WELWYN HATFIELD BOROUGH COUNCIL – DEVELOPMENT MANAGEMENT
DELEGATED REPORT

APPLICATION No: W6/2015/1274/EM

SITE ADDRESS: 68 Brockswood Lane, Welwyn Garden City, AL8 7BQ

DESCRIPTION OF DEVELOPMENT: Installation of a detached timber garden room

Project Details
 QUINTO+1 SUFFOLK BARN
 SMART OFFICE
 ELEVATIONS

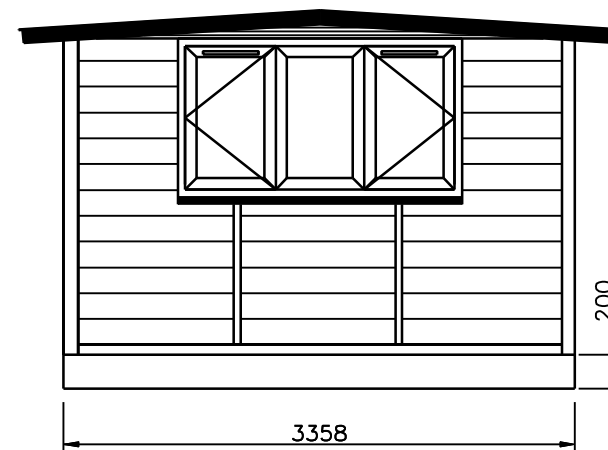
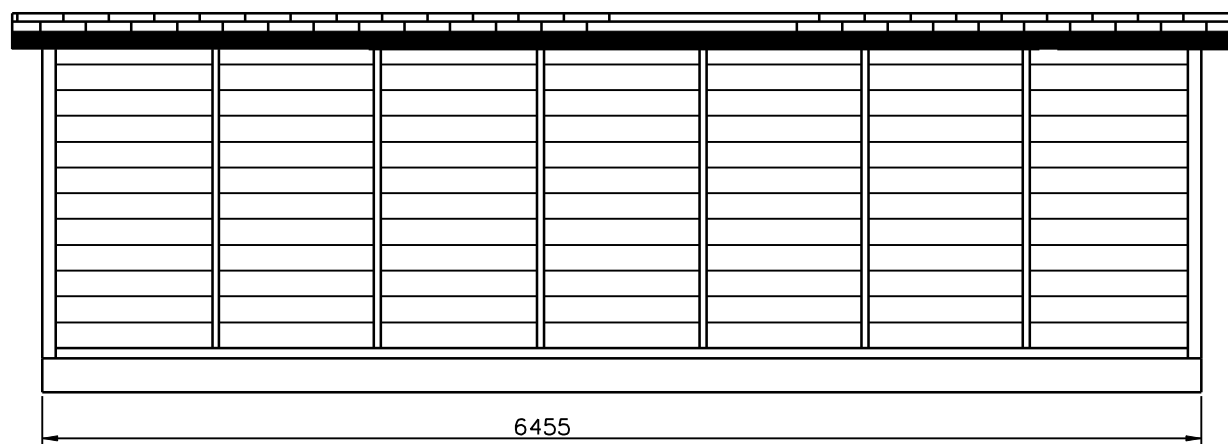
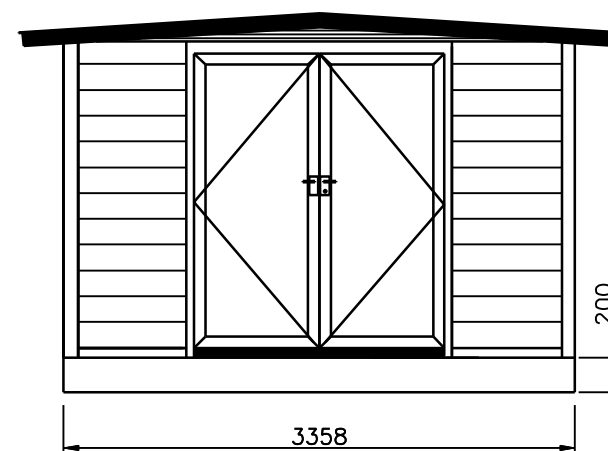
Comment: The proposed garden building, measuring 3.35m in depth, 7.64m in width and to a maximum height of 2.5m to the highest point of the roof ridge, is acceptable in principle for an ancillary use to the host property. It would be positioned where currently there is a sectional concrete garage adjacent to the boundary with the neighbouring house and garden. An established fence approximately 1.8 m in height divides the two gardens.

By virtue of its scale, location and its maximum height of only 2.5m, it is not considered that it would detract from the architectural appearance and character of the main dwelling on the site, or indeed adjoining dwellings.

The materials would be timber which is reasonable in this location for schemes of this nature.
